20 September 2016
DOC16/385277

Bylong Coal Project SSD 14_6367 – Bilateral Assessment

OEH review of the assessment of EPBC-listed threatened species and ecological communities in the Bylong Coal Project

Figure 4-1: Biodiversity Offset Areas

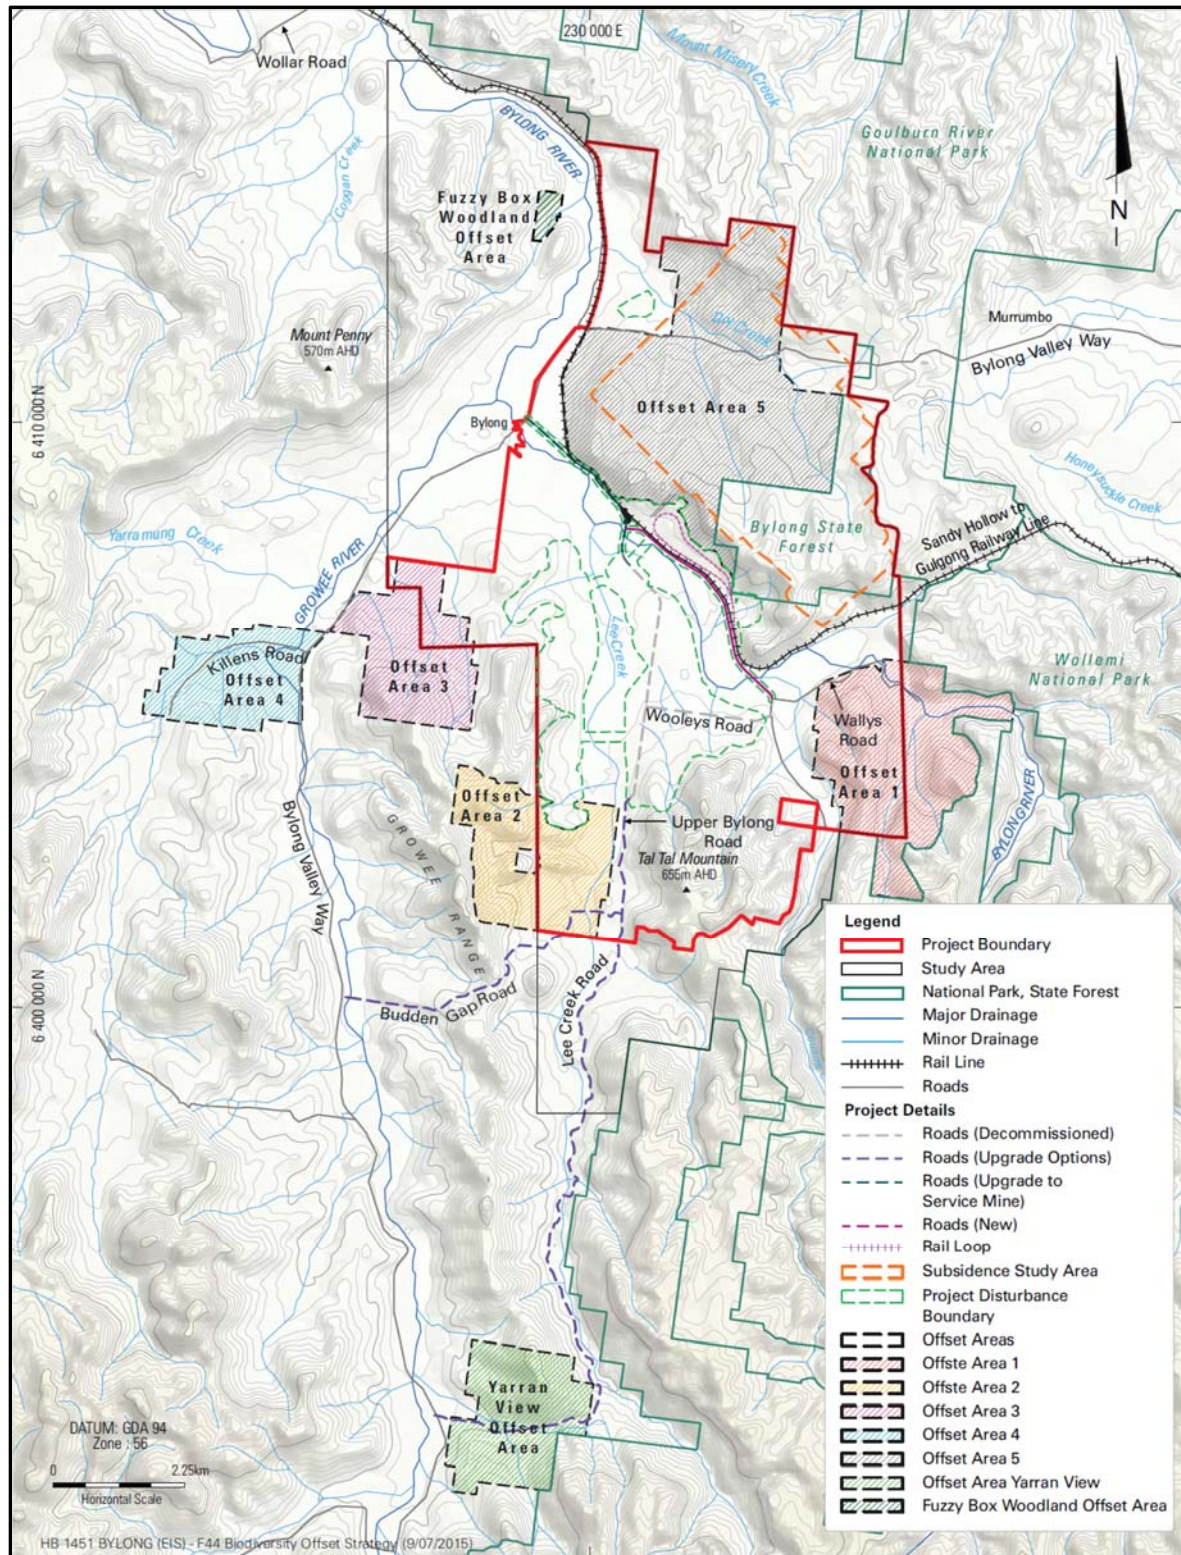
EPBC-listed ecological community	Veg Unit	Associated PCTs	Area	Credits generated
White Box-Yellow Box-Blakely's Red Gum Grassy Woodland and Derived Native Grassland	6a1	PCT 437 (HU732) - Yellow Box grassy woodland on lower hillslopes and valley flats in the southern NSW Brigalow Belt South Bioregion	138.38	2,162
	7a1	PCT 483 (HU690) - Grey Box x White Box grassy open woodland on basalt hills in the Merriwa region, upper Hunter Valley	514.77	6,096
	DNG6(1)	PCT 437 (HU732) DNG	75.27	992
	DNG7(1)	PCT 483 (HU690) DNG	519.73	5,419
	DNG6(2)	PCT 437 (HU732) DNG	94.69	1,005
	DNG6(3)	PCT 437 (HU732) DNG	26.9	389
	DNG7(2)	PCT 483 (HU690) DNG	164.98	1,886
	DNG7(3)	PCT 483 (HU690) DNG	154.09	2,284
TOTAL			1,688.8	20,233

Total number of ecosystem credits available from the offset areas (20,233) is well in excess of the number required (5,259 section 11).
